PROJECT NO. PR-2021-005411

Application No. SI-2021-00760

**RE: AUTONATION DRB RESPONSE TO COMMENTS
PR-2021-005411**

Per the correspondence via email of Ms. Jeanne Wolfenbarger, P.E., Transportation Development, dated June 22, 2021, please find the following responses addressing the comments listed below:

A2.11

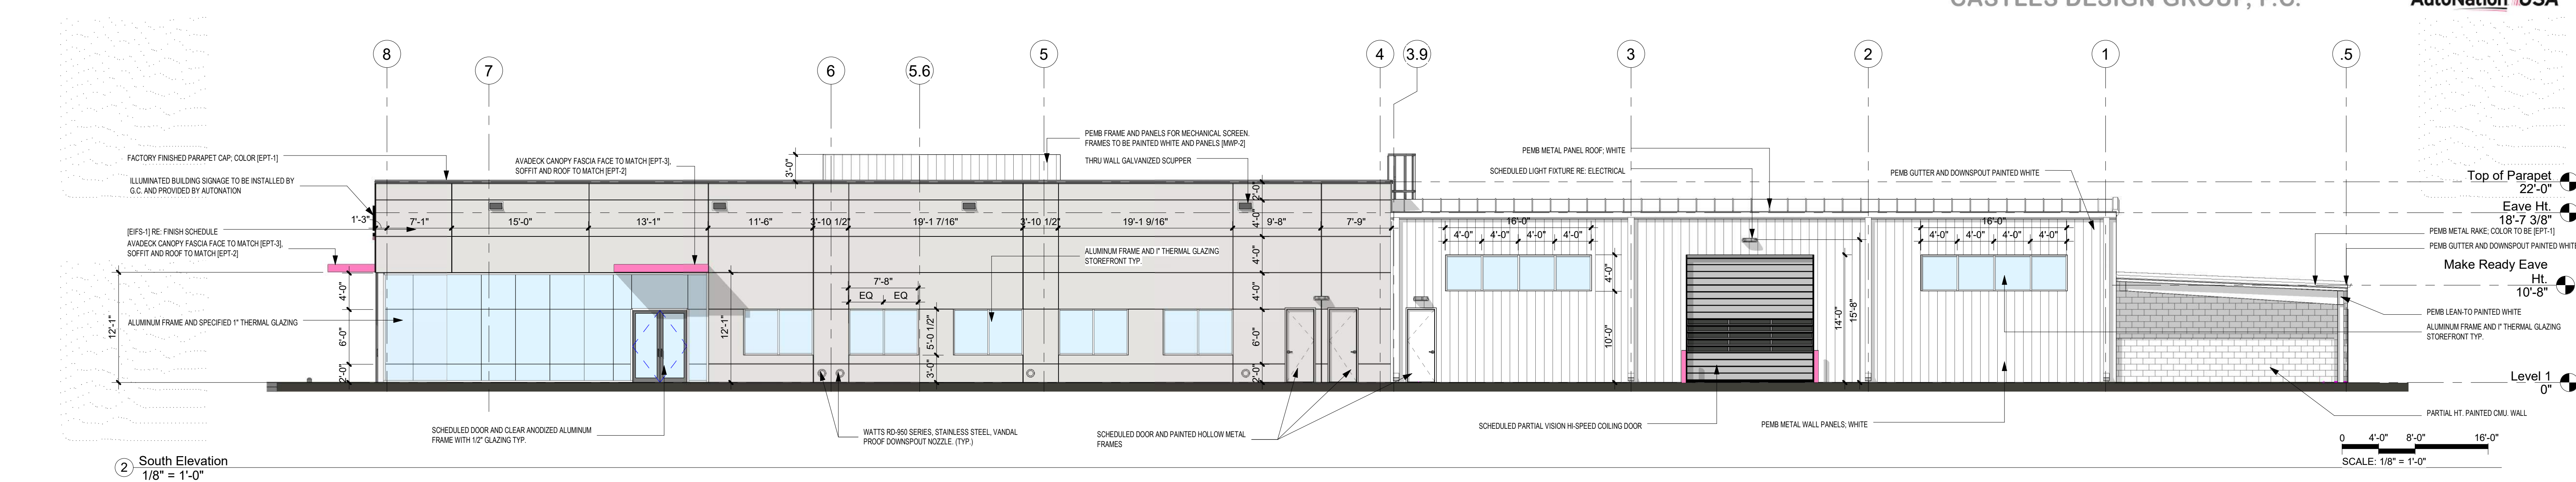
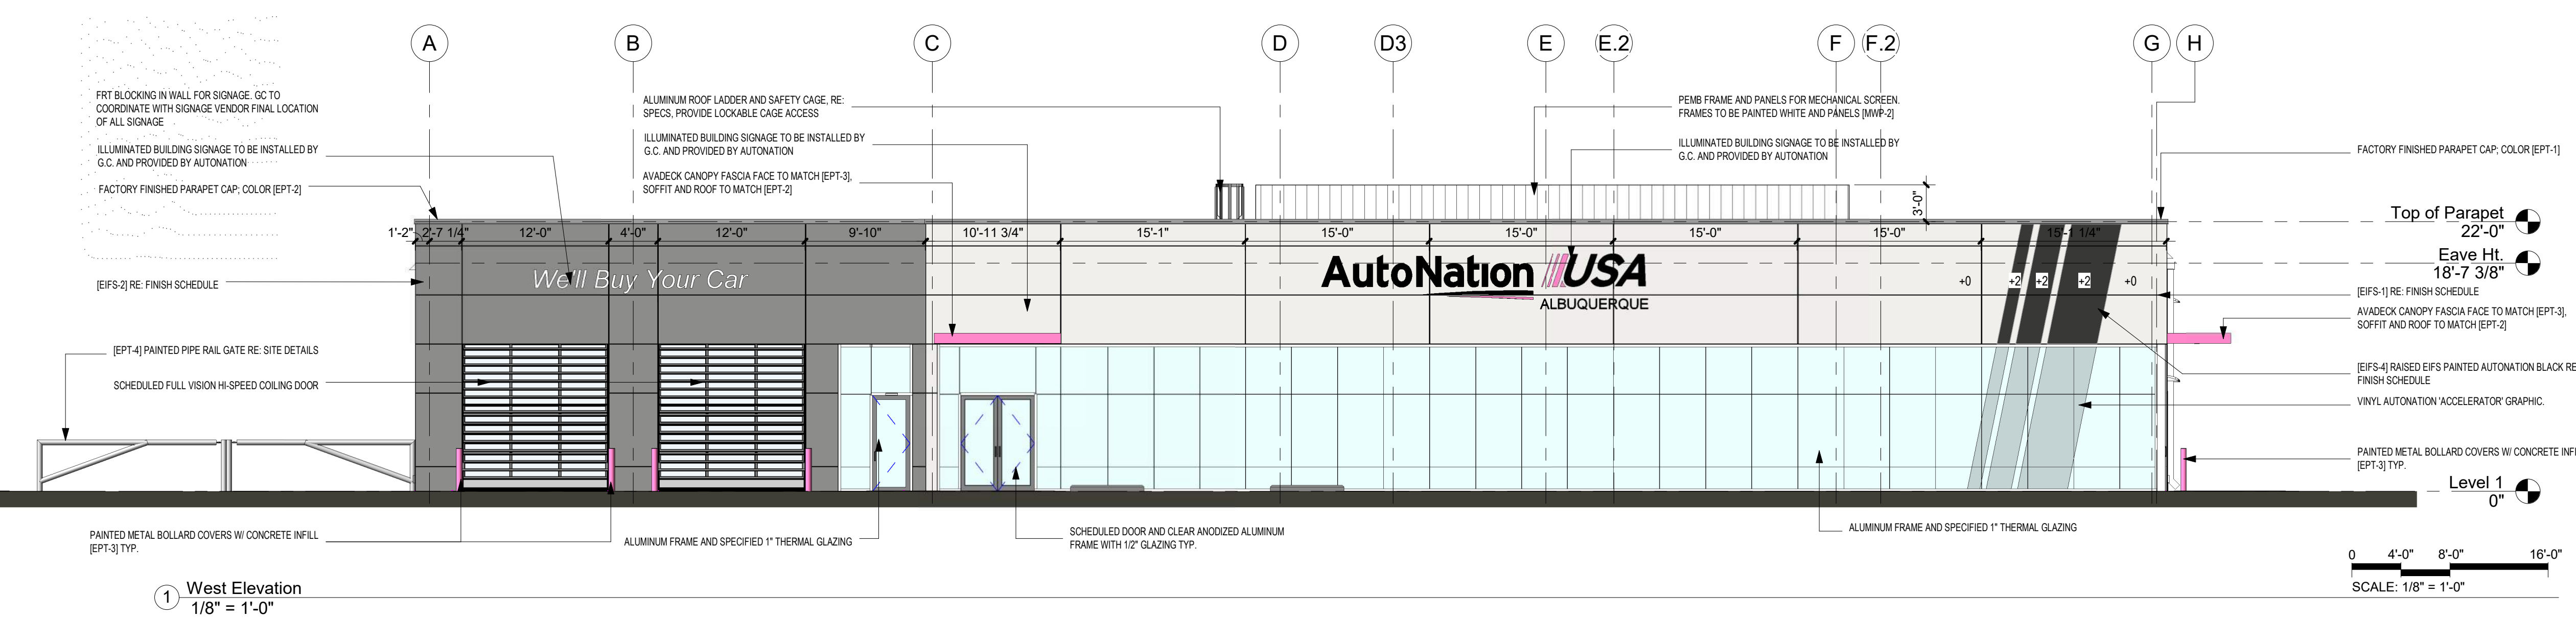
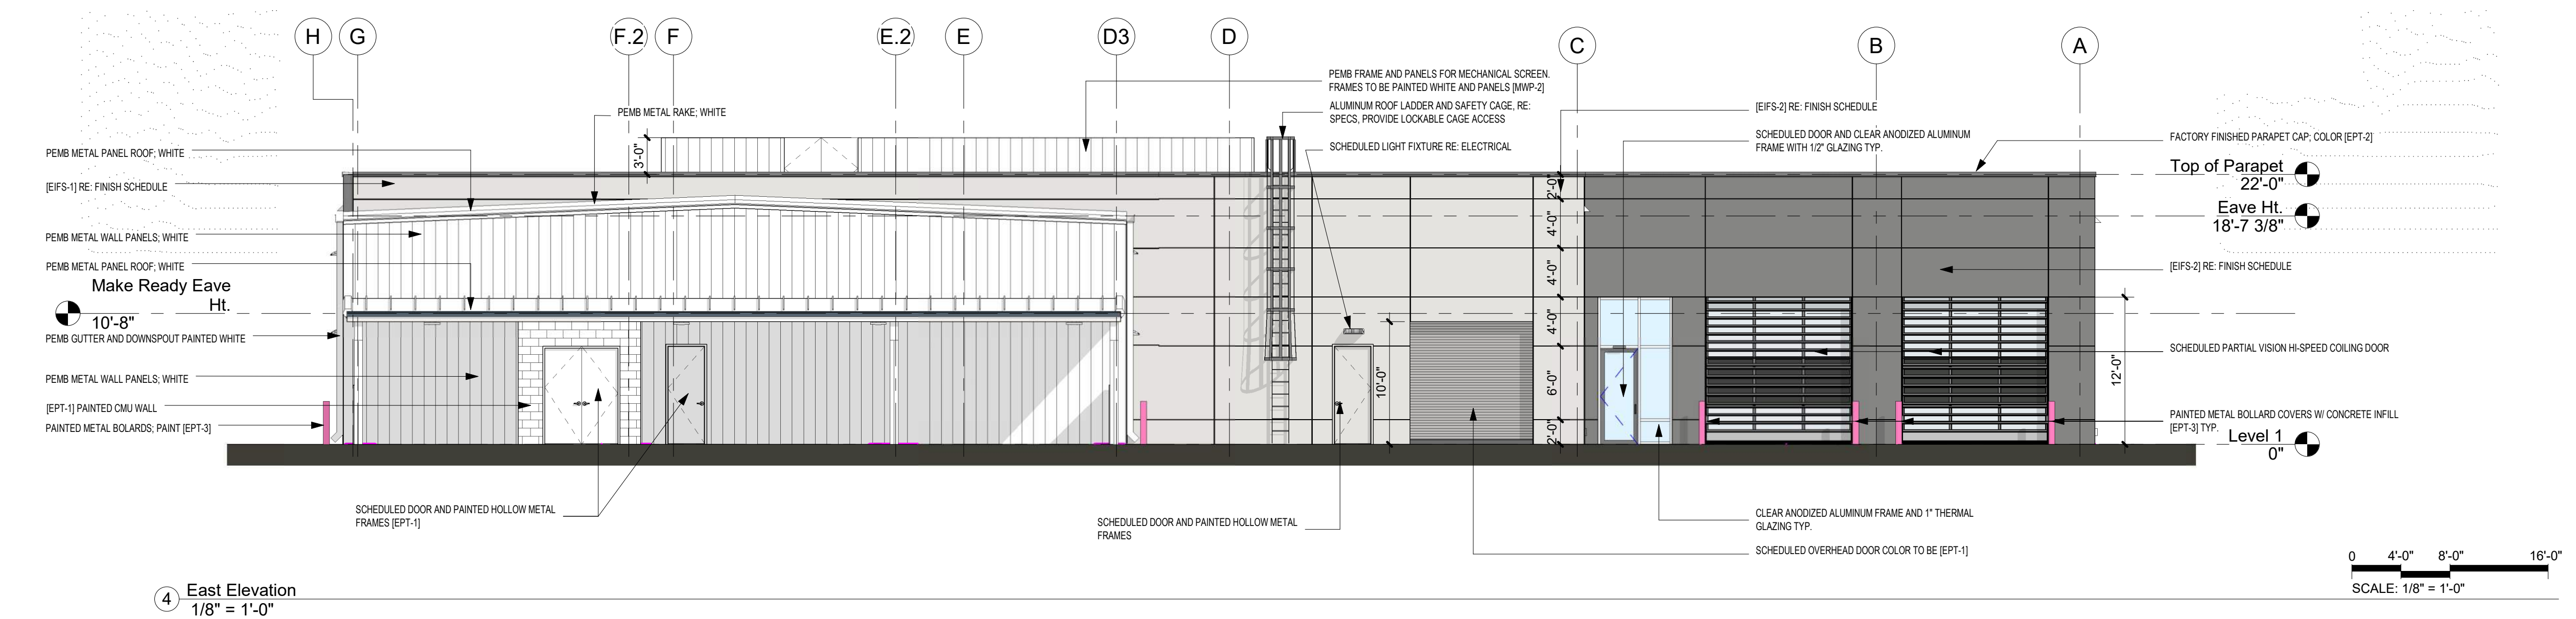
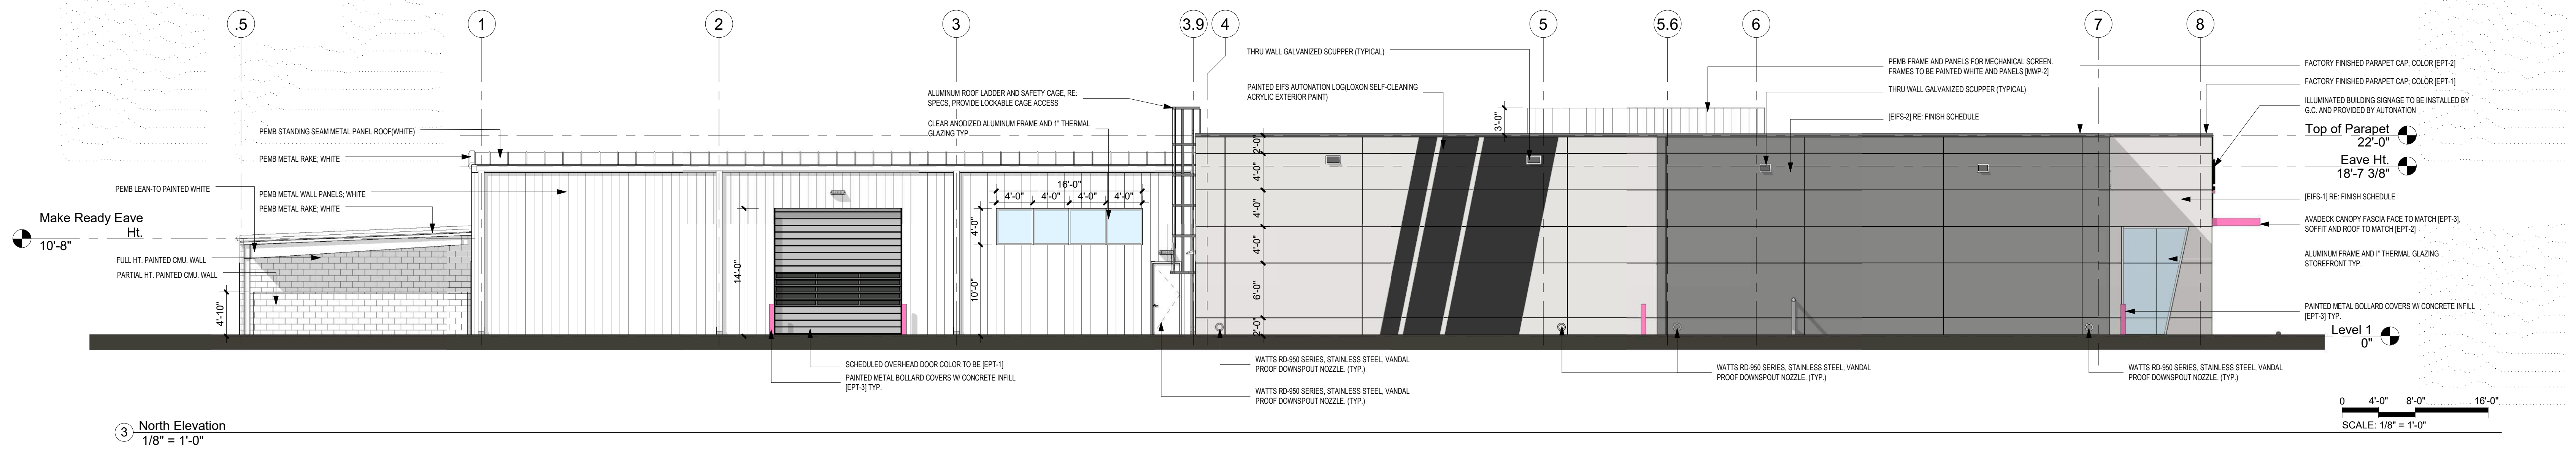
11. Due to the presence of NR-BP zoning on the site, the applicant must demonstrate on the Site Plan and/or in a comment response letter how the Building Design requirements of 5-11(E) of the IDO are being met.
See attached response letter from the architect on how the IDO requirements are being met.

AUTO NATION ALBUQUERQUE, NM	DRAWN BY pm
	CONSTRUCTION DETAILS	DATE 7-13-21
	TIERRA WEST, LLC 5571 MIDWAY PARK PL. NE ALBUQUERQUE, NEW MEXICO 87109 (505) 858-3100 www.tierrawestllc.com	DRAWING 2021010-DET
RONALD R. BOHANNAN P.E. #7868		SHEET # DET-1
		JOB # 2021010

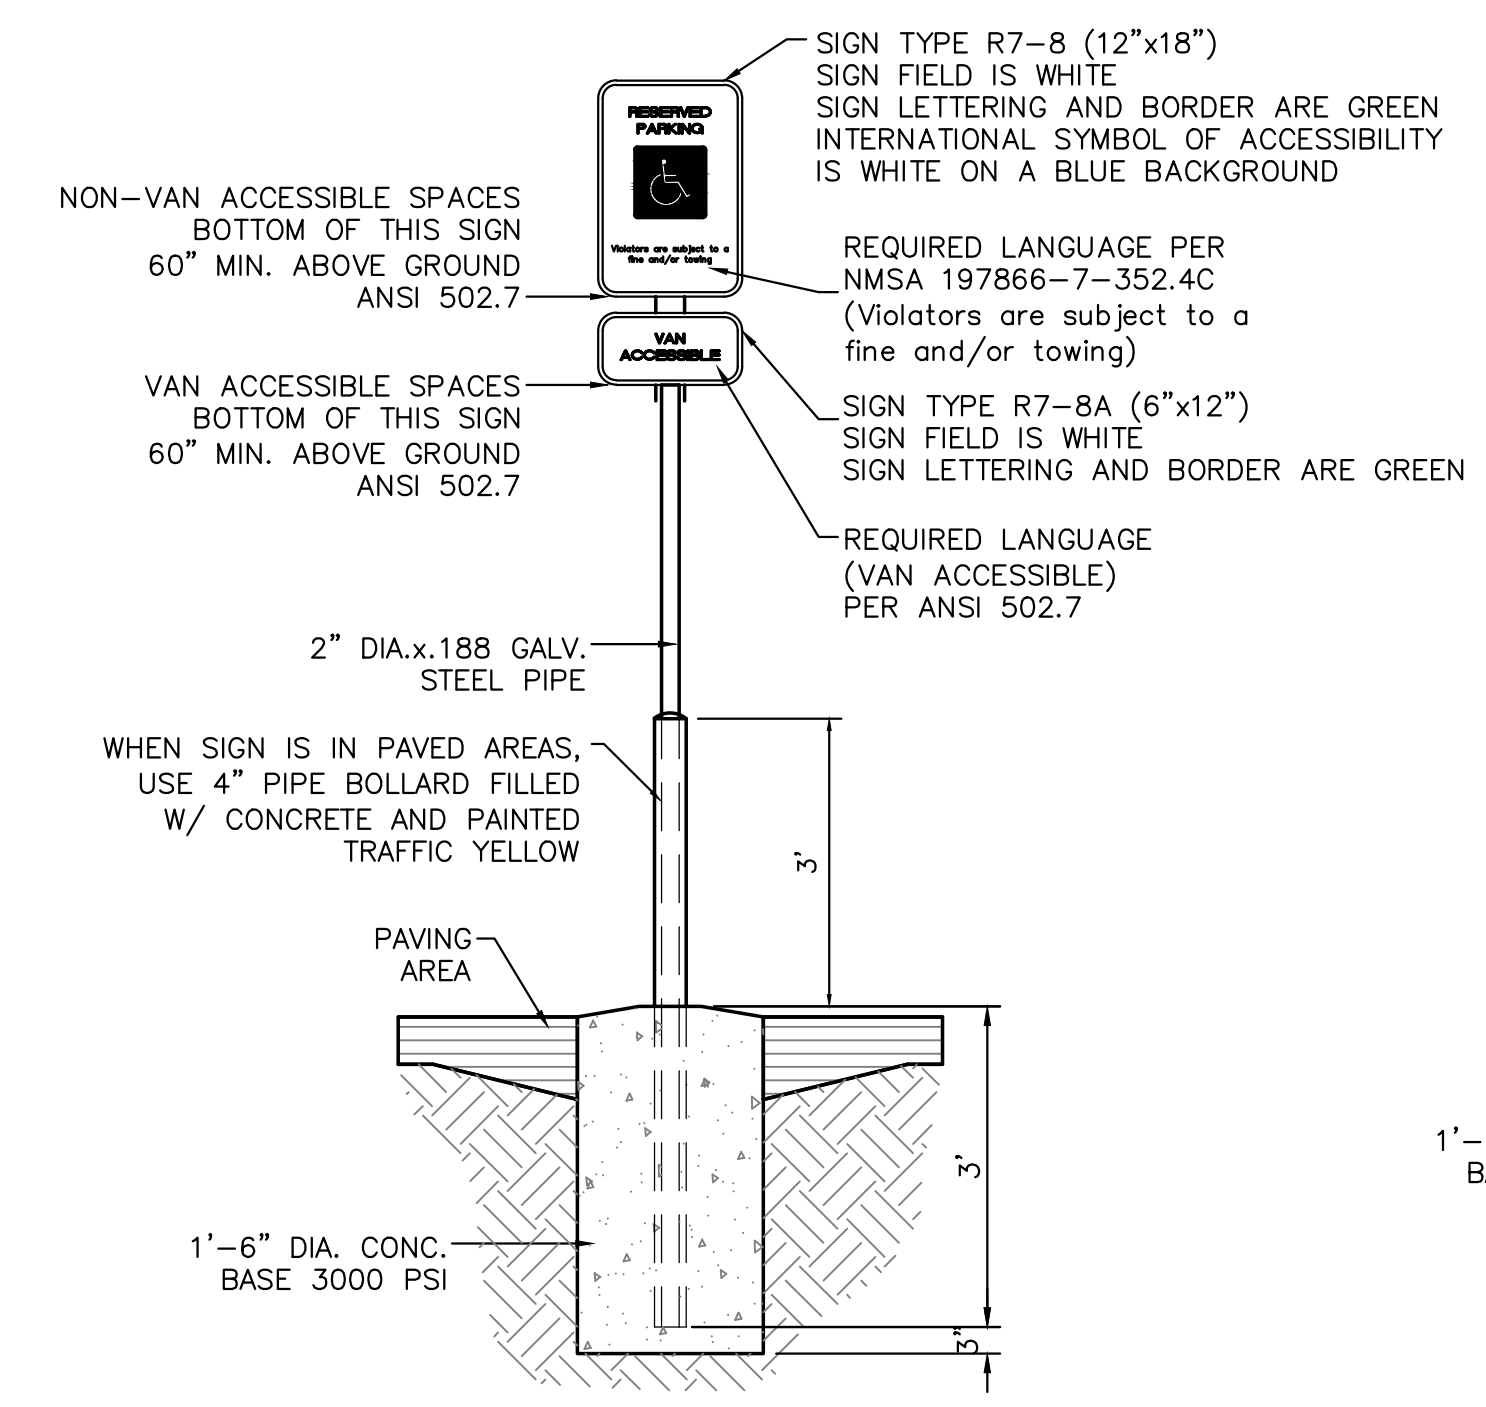
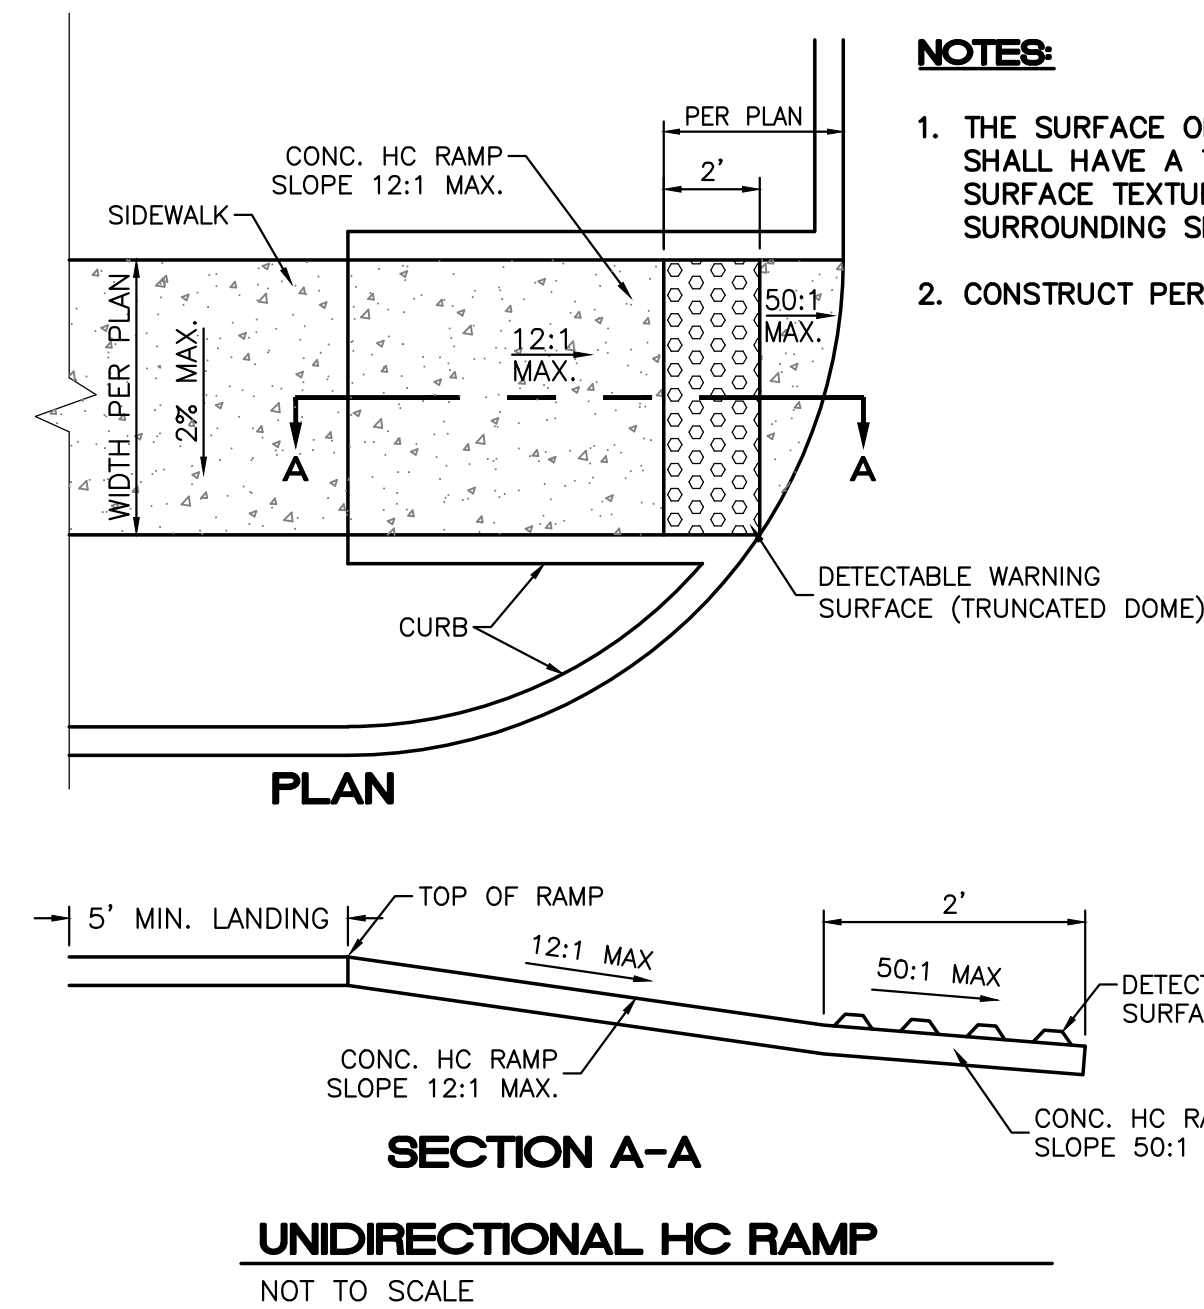
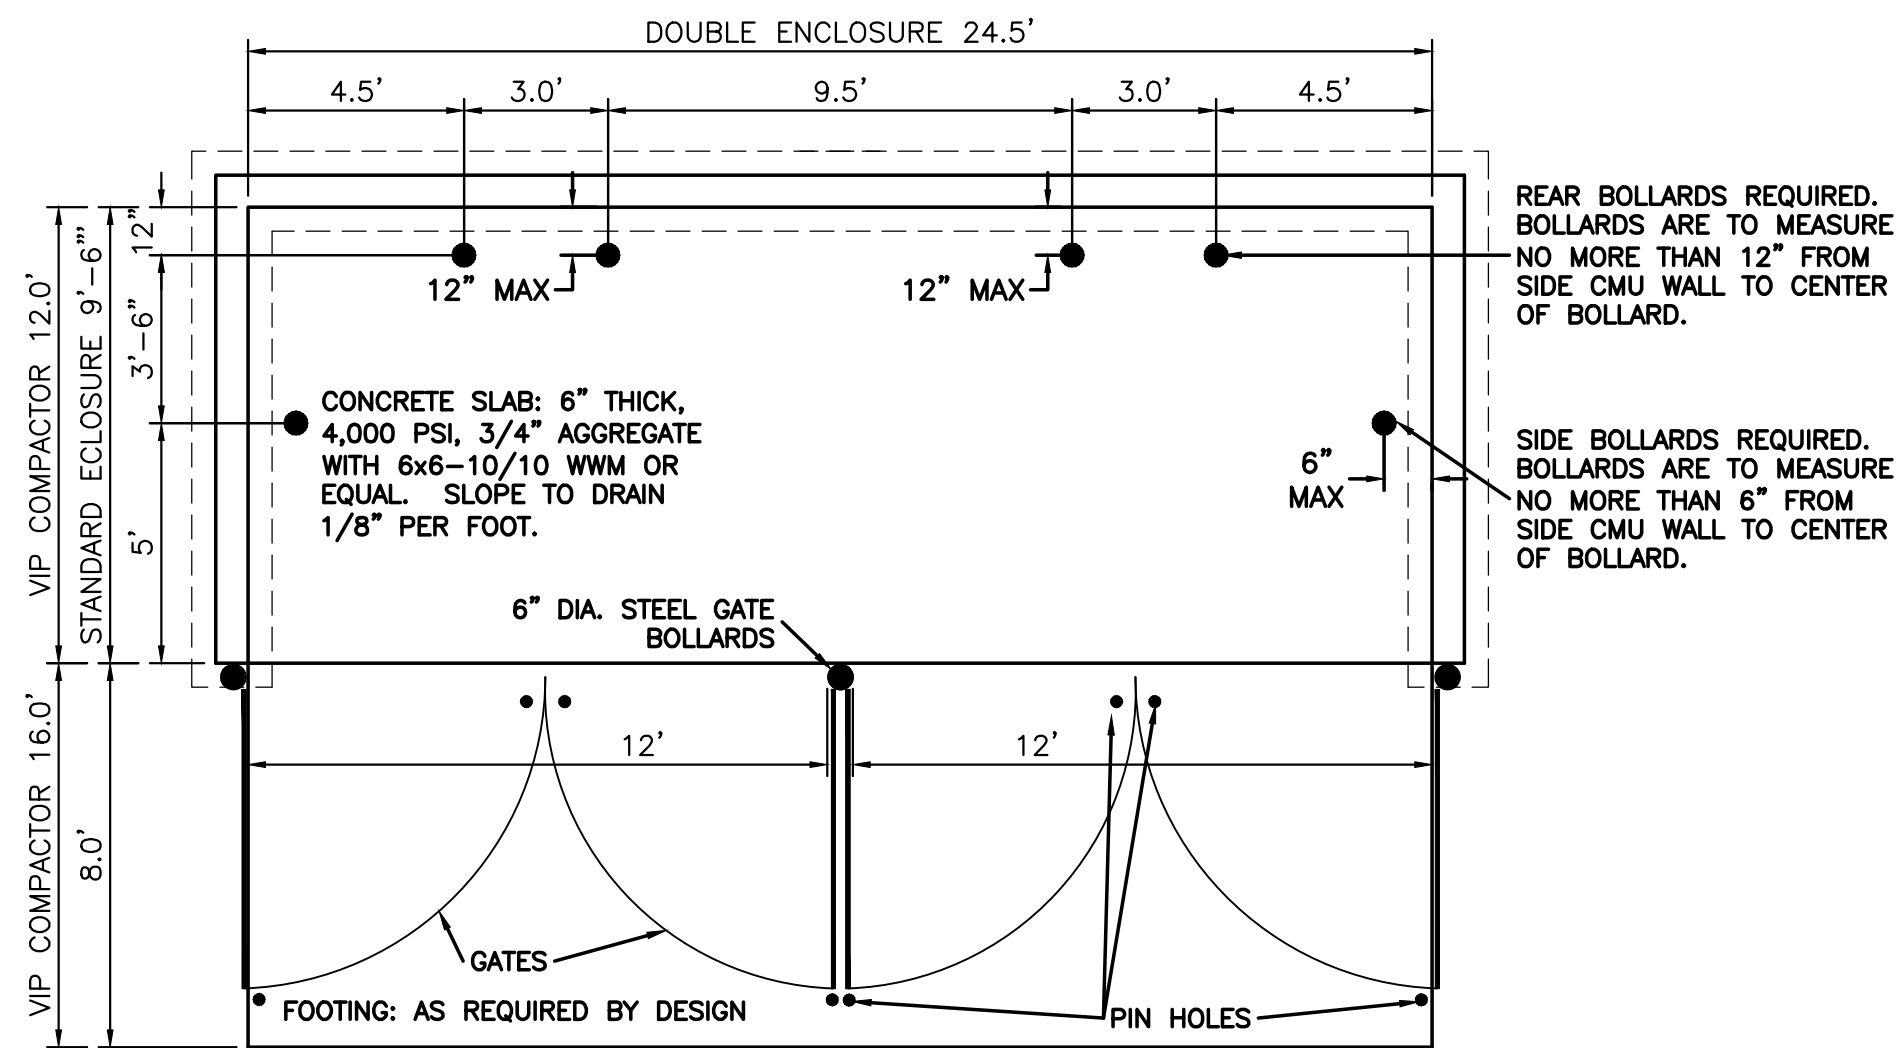
10. Provide an enlarged plan view of the bike rack area, demonstrating sufficient bicycle parking dimensioning according to standards.

12. Provide keyed notes with curb ramp detail references, and provide all necessary types of curb ramps to match what is on the plan.

14. Show "No Parking" in back of all of the handicapped accessible aisles.

16. On sidewalk detail, call out a 2% maximum cross-slope.

The enlarged bike area is now shown on Sheet DET-1

Keyed notes were added for each ramp design and separate details can be found on Sheet DET-1.

The "No Parking" lettering is shown on the Accessible Parking Detail found on Sheet DET-1.

This note was added to the detail found on Sheet DET-1.
